Our Ref: TR010022

Planning Act 2008 (as amended) – Section 51

Application by Highways England for an Order Granting Development Consent for the A38 Derby Junctions.

Advice following issue of decision to accept the application for examination

FIGURE 5.2B  
STUDY AREA FOR CONSTRUCTION  
PHASE TRAFFIC IMPACTS

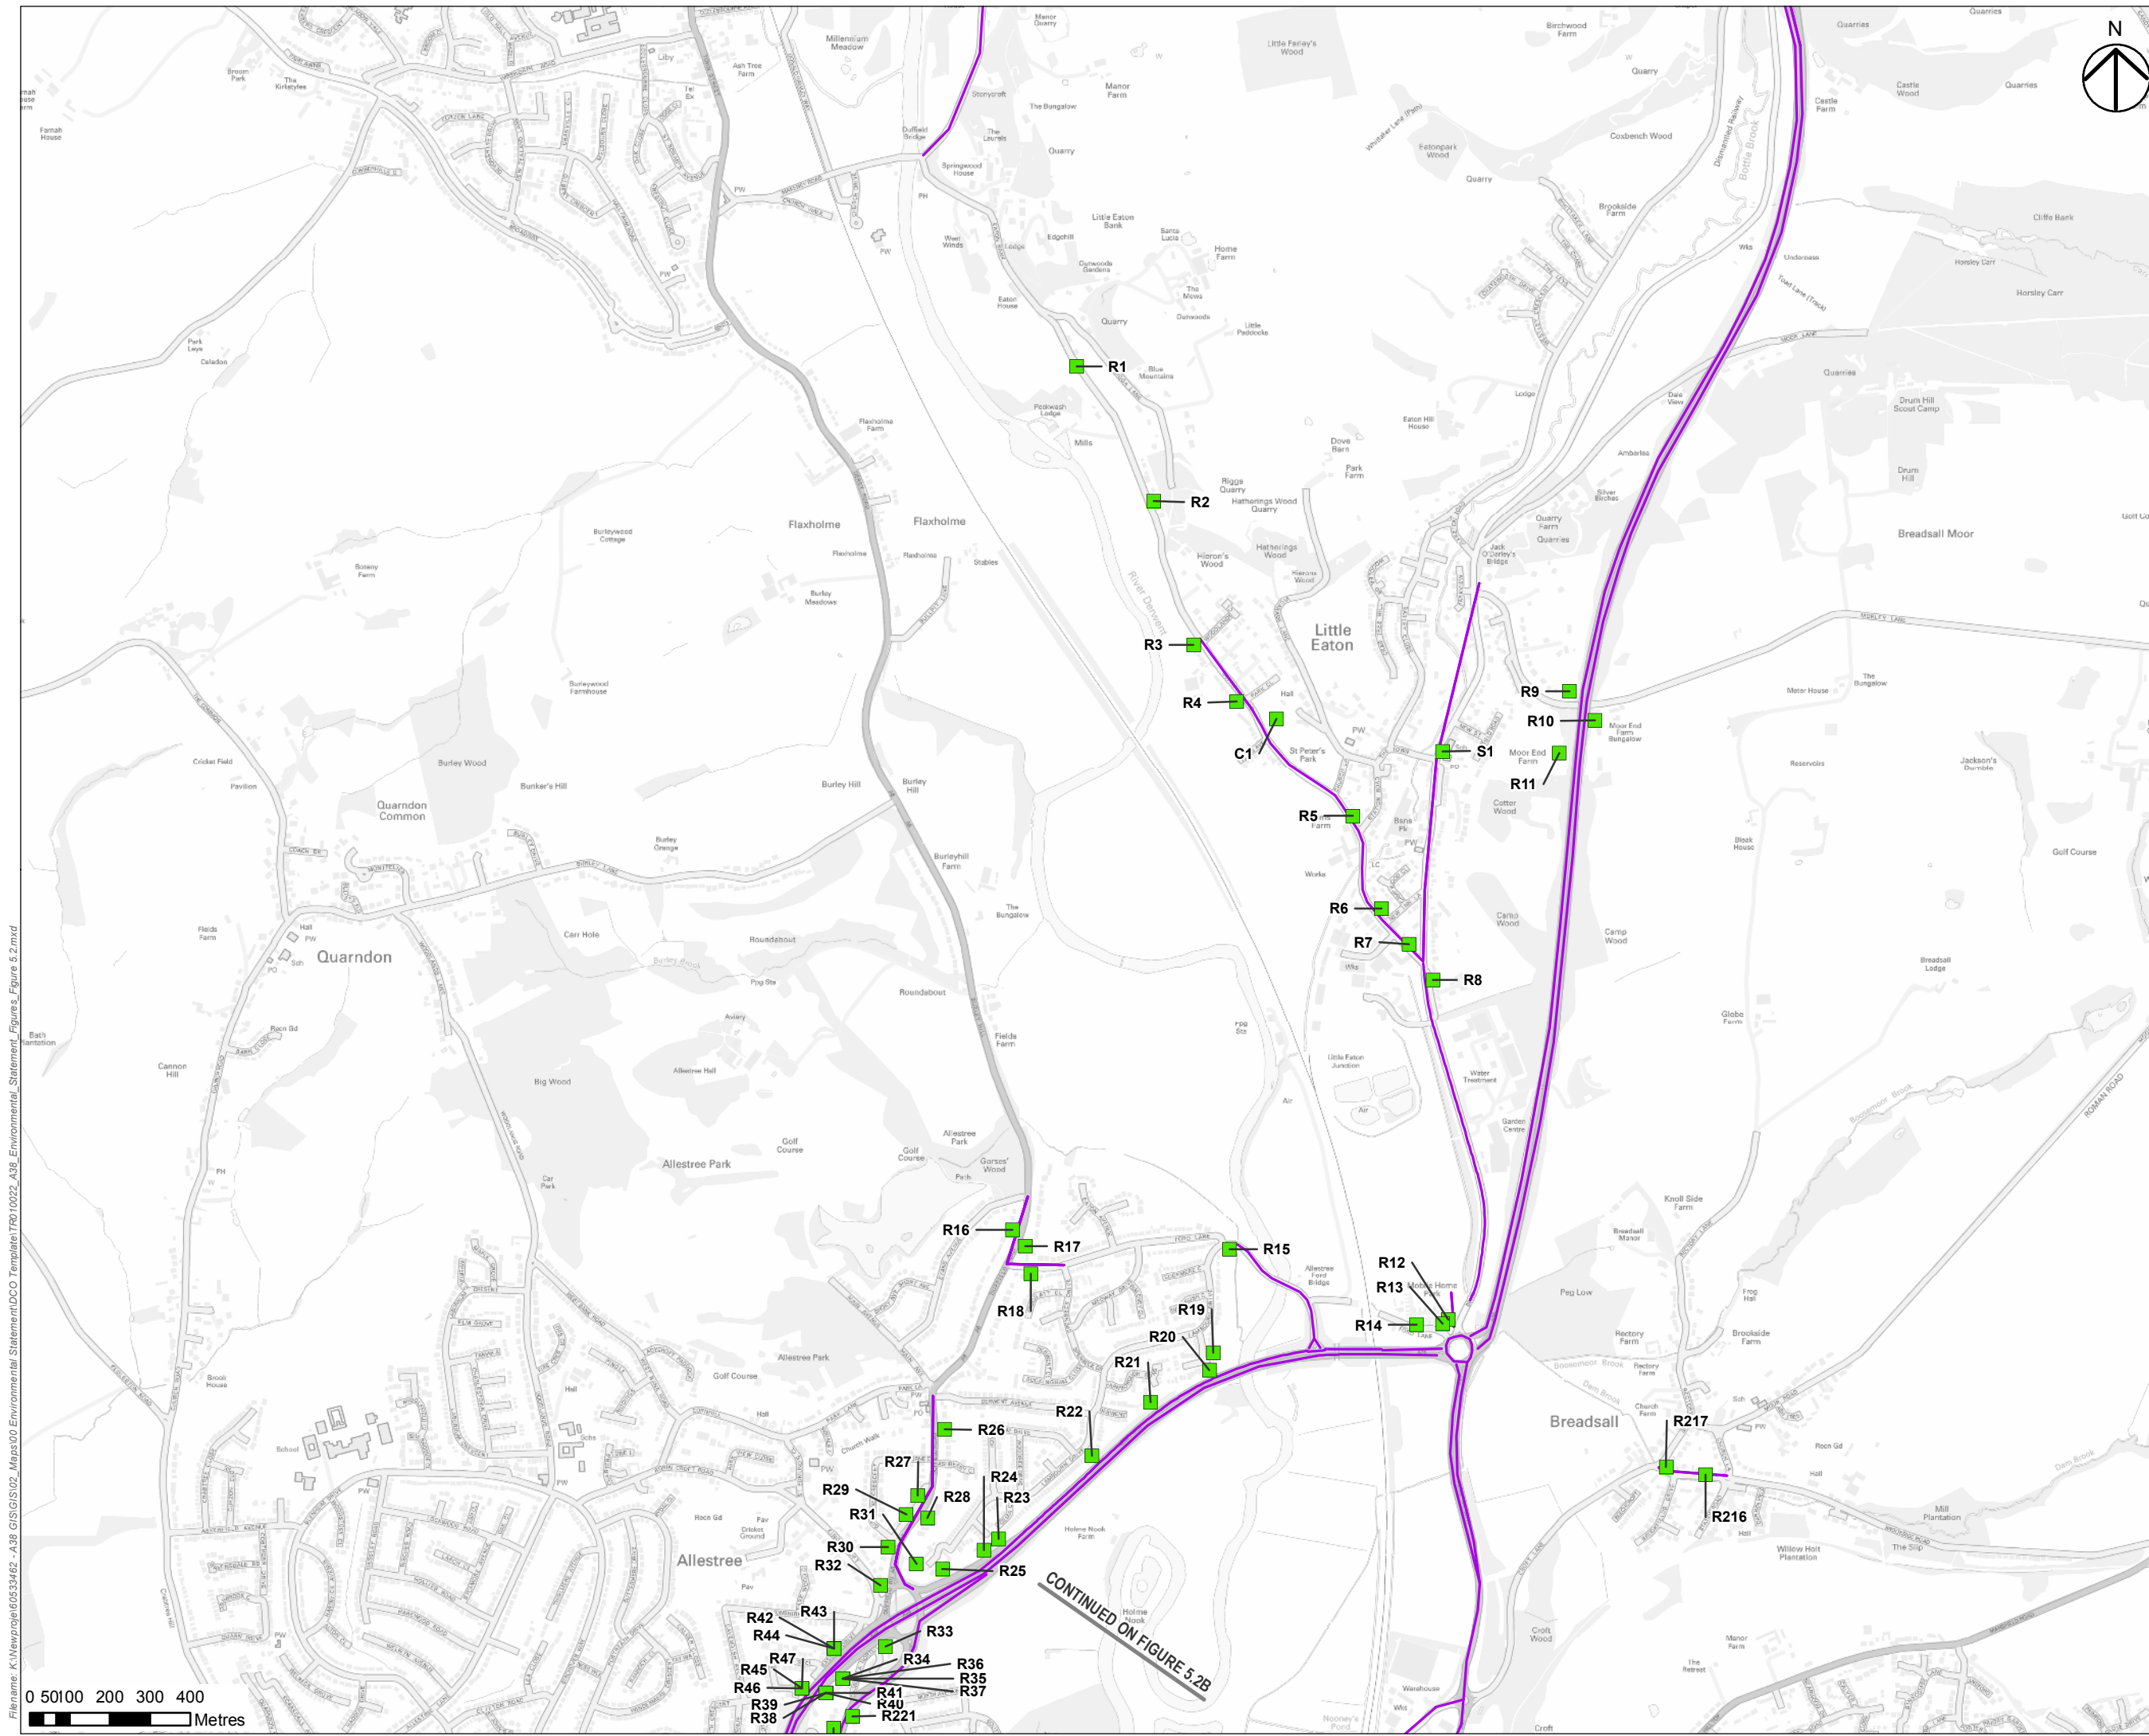
ES chapter 5, paragraph 5.6.2 states that the assessment of "*operational phase traffic effects uses a study area of 200m around roads likely to be affected by the Scheme*" and ES paragraph 5.6.3 sets out standard screening criteria used to determine study areas. Figures 5.2a-c and 5.3a-c set out the receptors considered in the construction phase and the opening year of operation. However, no detailed information is provided to explain how the selected receptors were derived with reference to the 200m study area and screening criteria thresholds. Please provide further detail regarding the findings of the receptor screening process set out in the ES.
